# CITY OF ALBUQUERQUE

**Re: Heritage Marketplace  
Drainage Report and Grading and Drainage Plans  
Engineer's Stamp Date 3-25-15 (H09D024)**

RE: HERITAGE MARKET PLACE (H09D024)

Drawing file: H09D024 / 2014038-GR-C-6.pdf

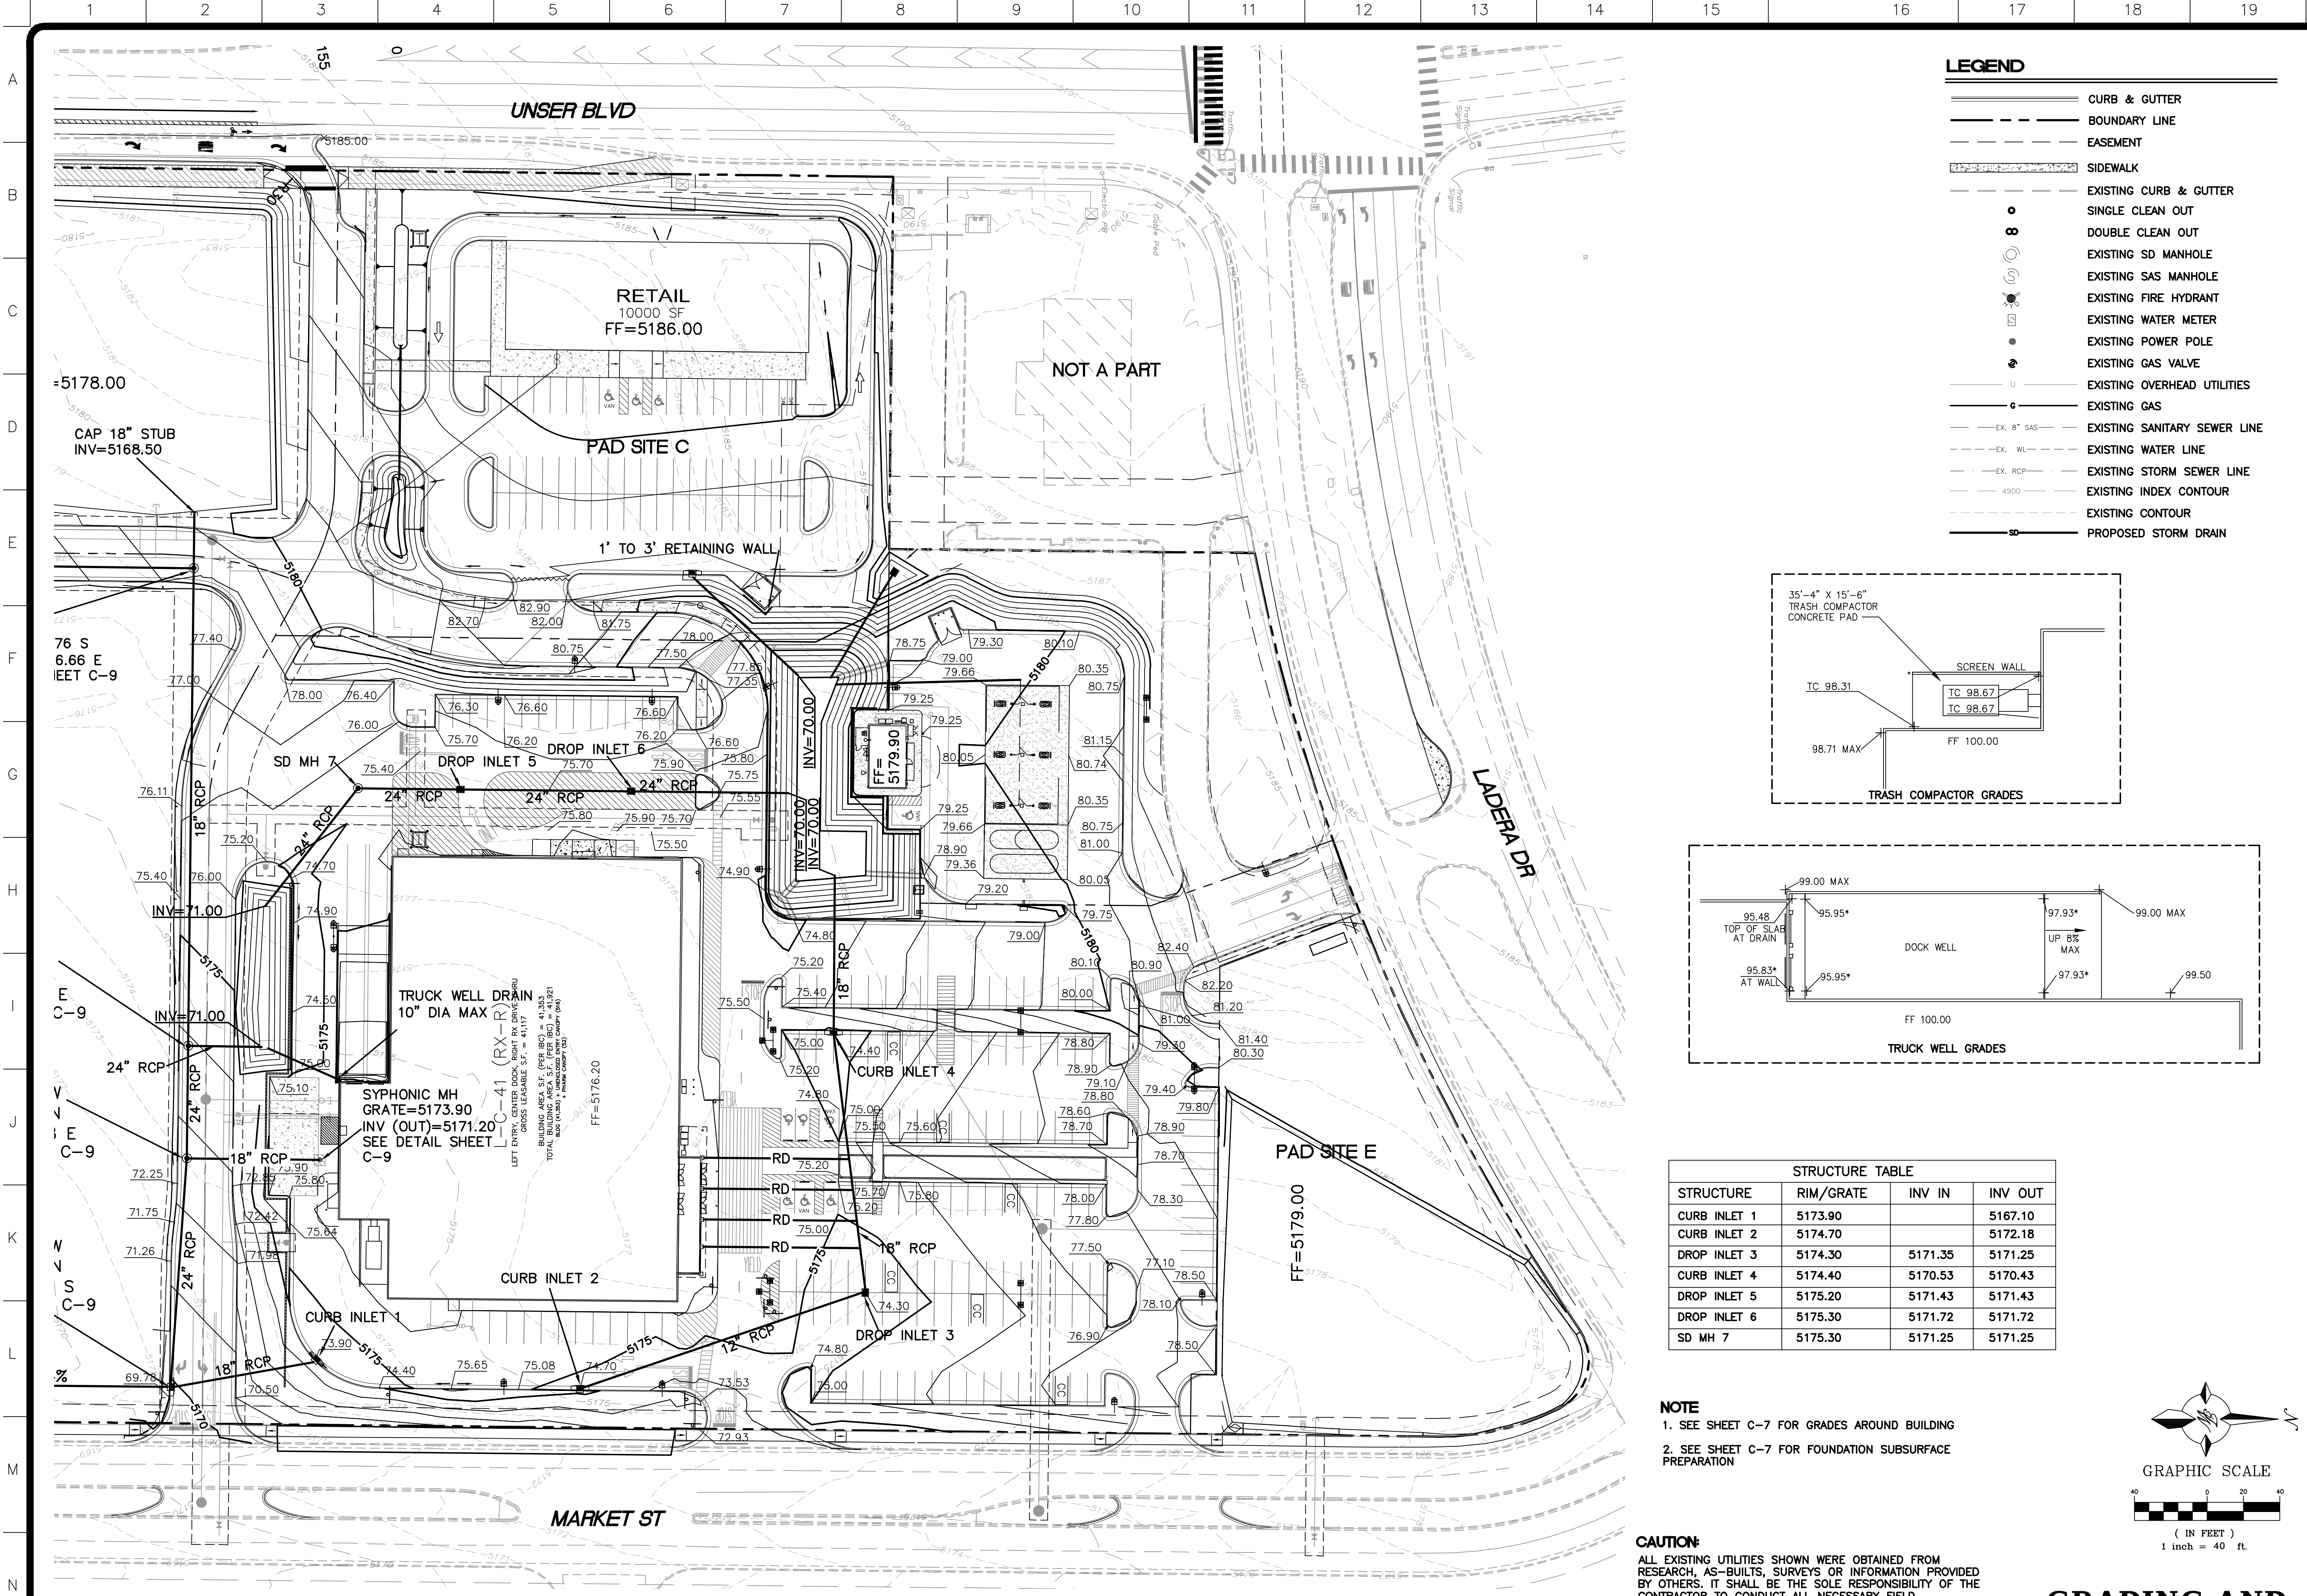
1. It appears the sump near Pad Site A and the pad grade of Pad Site A is lowering the storm drain profile and making it difficult to drain Basin B3 into Pond 2 to capture the first flush. If the road was straight-graded and Pad Site A raised, this would create enough grade to raise the storm drain profile and drain Basin B3 into Pond 2.

2. The first flush runoff from the roof of the anchor store should be retained. The finished floor elevation is 76.2 and the pond bottom is at 71 (70 in first flush calcs), so it appears easy to capture this stormwater.

**Response: The grading design was revised to incorporate a water quality basin within Pad Site A to account for Basin B3. We analyzed "straight-grading" the roadway, however, the elevations necessary at the driveway between Pad B and C made this option impractical.**

**Response: The roof drain connection was revised to connect to the pond behind the store, as requested.**

ENGINEER'S SEAL RONALD R. BOHANNAN P.E. # 7868	HERITAGE MARKET PLACE ALBUQUERQUE, NM	DRAWN BY pm
	GRADING PLAN	DATE 2-17-15
	TIERRA WEST, LLC 5571 MIDWAY PARK PL. NE ALBUQUERQUE, NEW MEXICO 87109 (505) 858-3100 www.tierrawestllc.com	DRAWING 2014038-SP
		SHEET NO GR-1
		JOB # 2014038

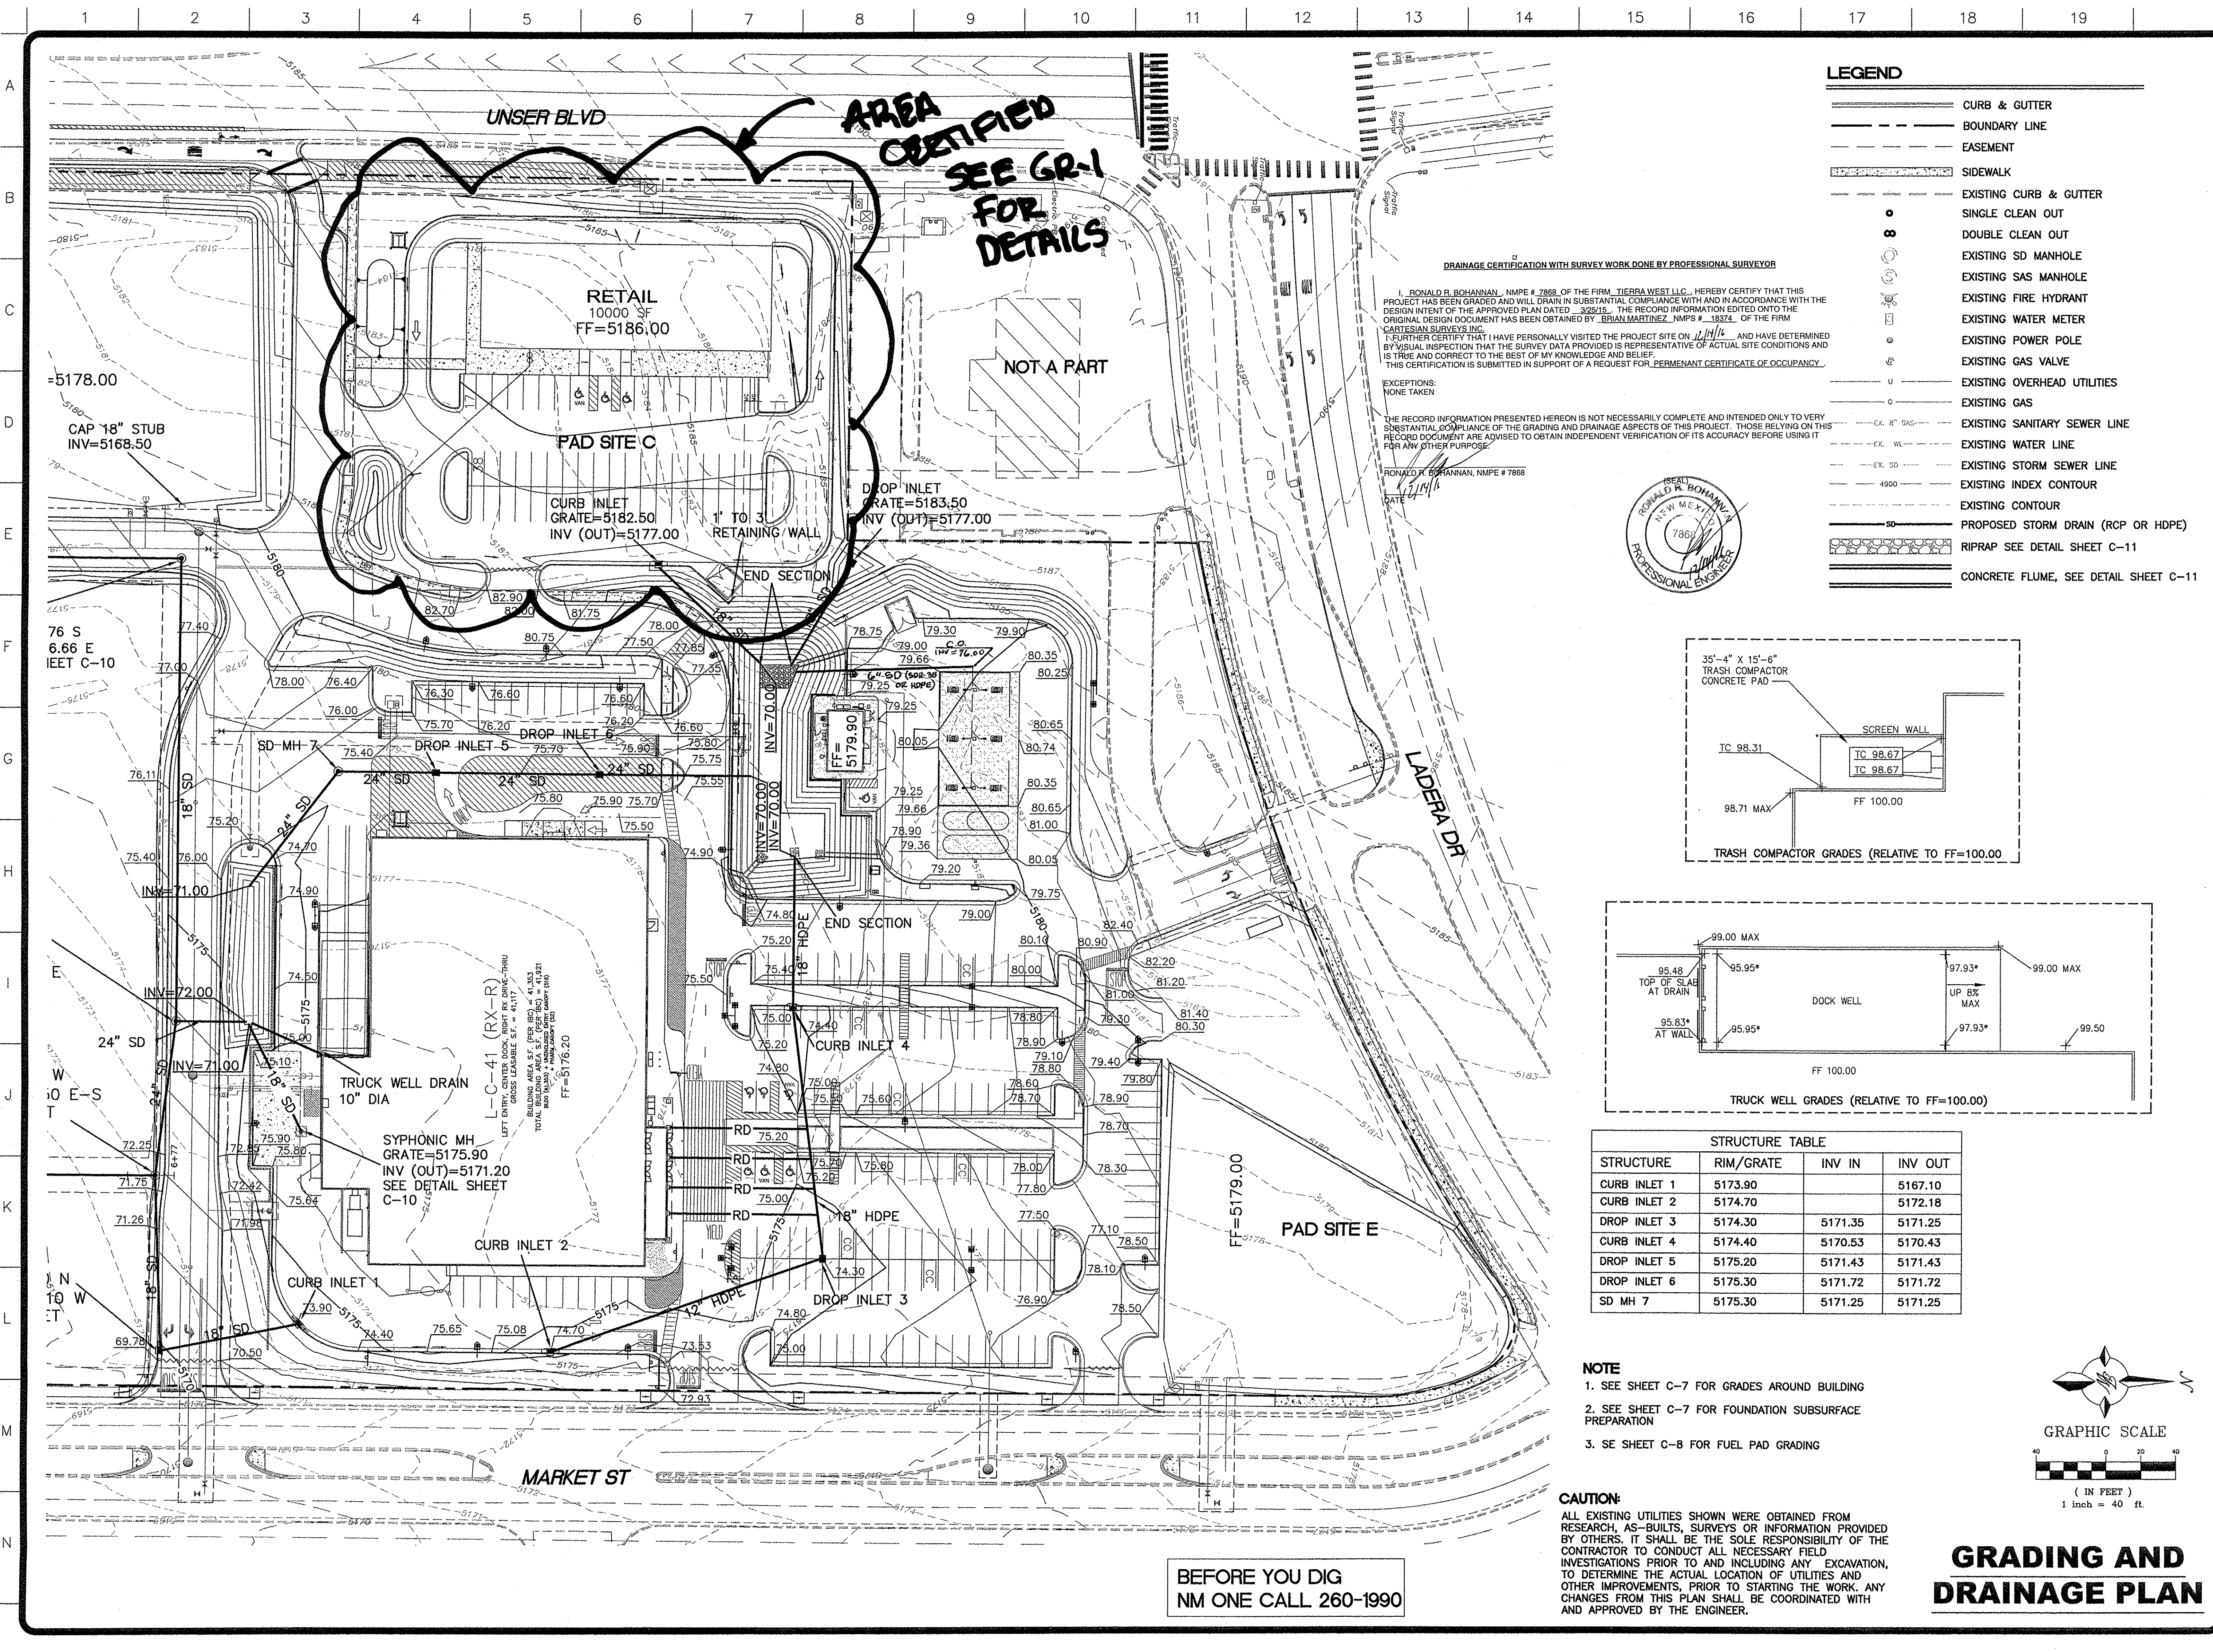
4. The narrative for pad site C is for a different location.

**Response: An updated grading plan is attached for review with narrative removed (analysis covered by drainage report).**
